Rezoning Transportation Analysis

Petition Number: #2022-099

Date	Description
11-28-22	First Review (IW)
12-22-22	Second Review (IW)
01-26-23	Third Review (IW)

**RZ-1**

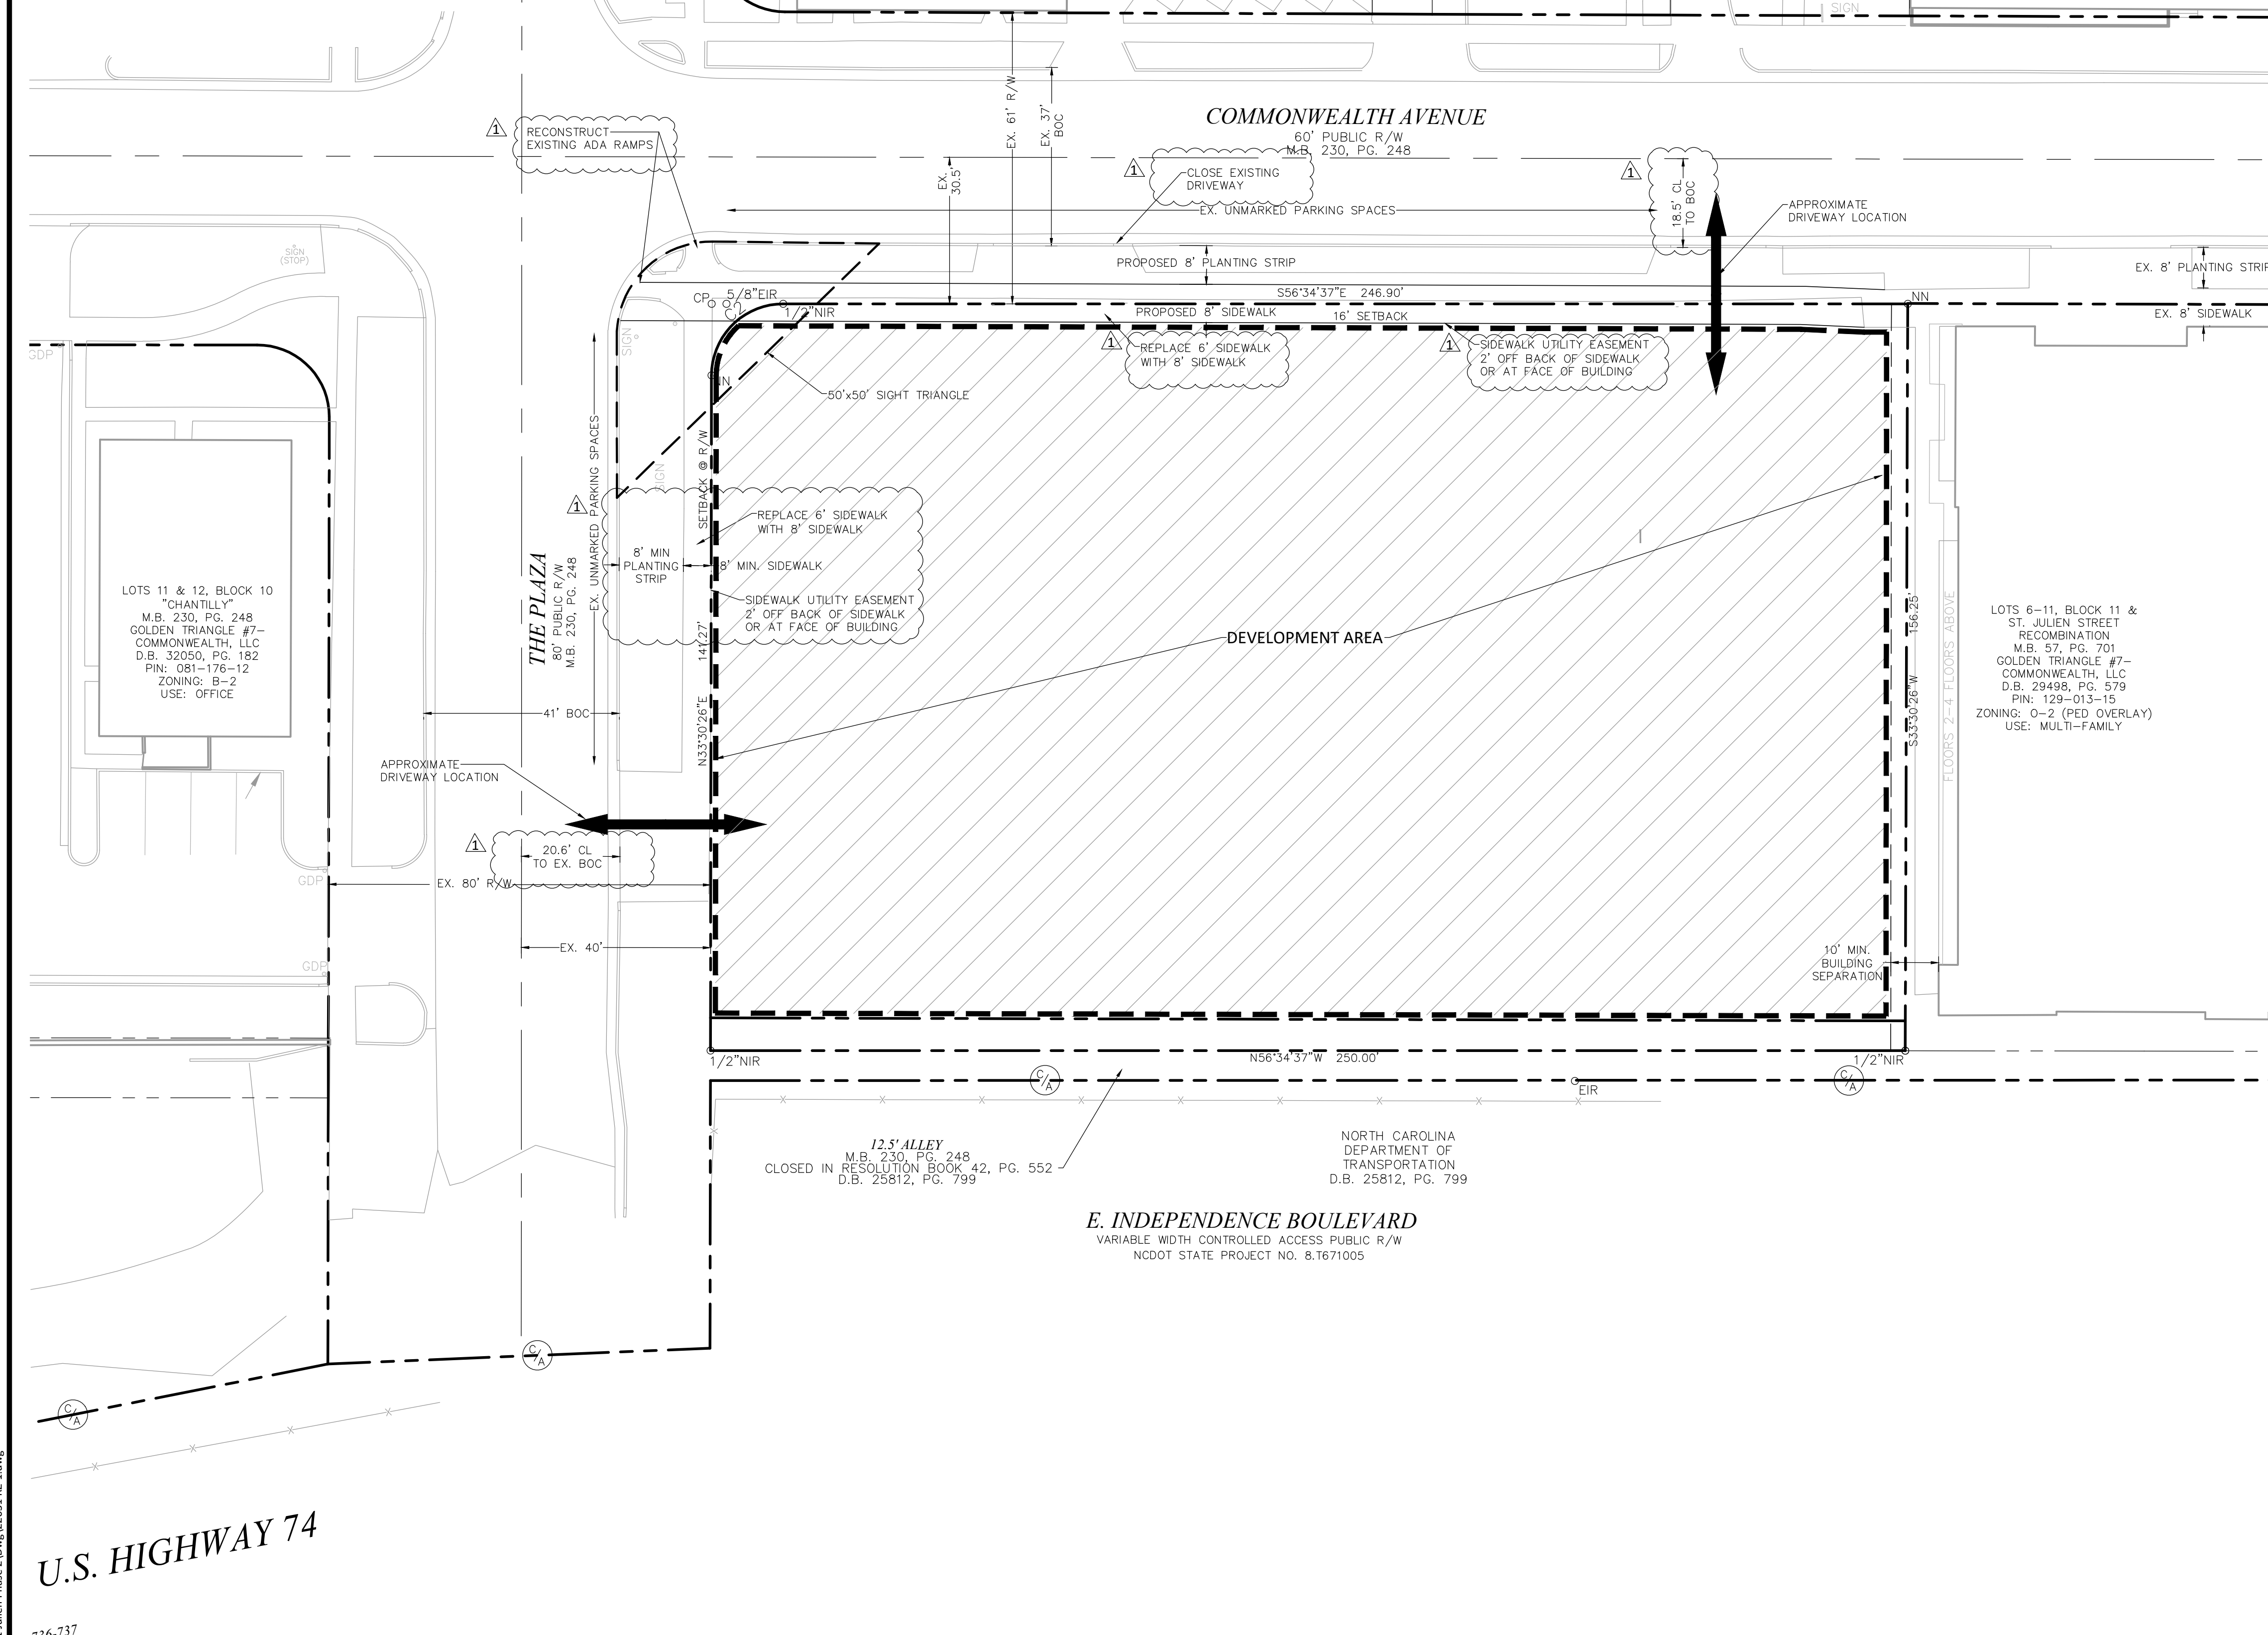
3. **Outstanding Comment from 11-28-22: Comprehensive Transportation Review (CTR):**

The Comprehensive Transportation Review was recently approved by City Council under the new UDO. In lieu of a TTM for the proposed site CDOT has requested the petitioner complete a CTR for the site. The petition's zoning falls within the medium to high intensity development which based on the 1,775 daily trips will trigger Tier 3 (14 mitigation points) for multimodal assessment and Tier 3 (6 mitigation points) for transportation demand management assessment.

The petitioner shall review and assess the publicly accessible pedestrian network within ¼ mile walking distance of the site to identify multimodal infrastructure to meet the Tier 3 (14 mitigation points) for multimodal assessment. Petitioner shall also provide transportation demand management strategies to meet Tier 3 (6 mitigation points) to reduce vehicle trips and encourage alternative modes of transportation.
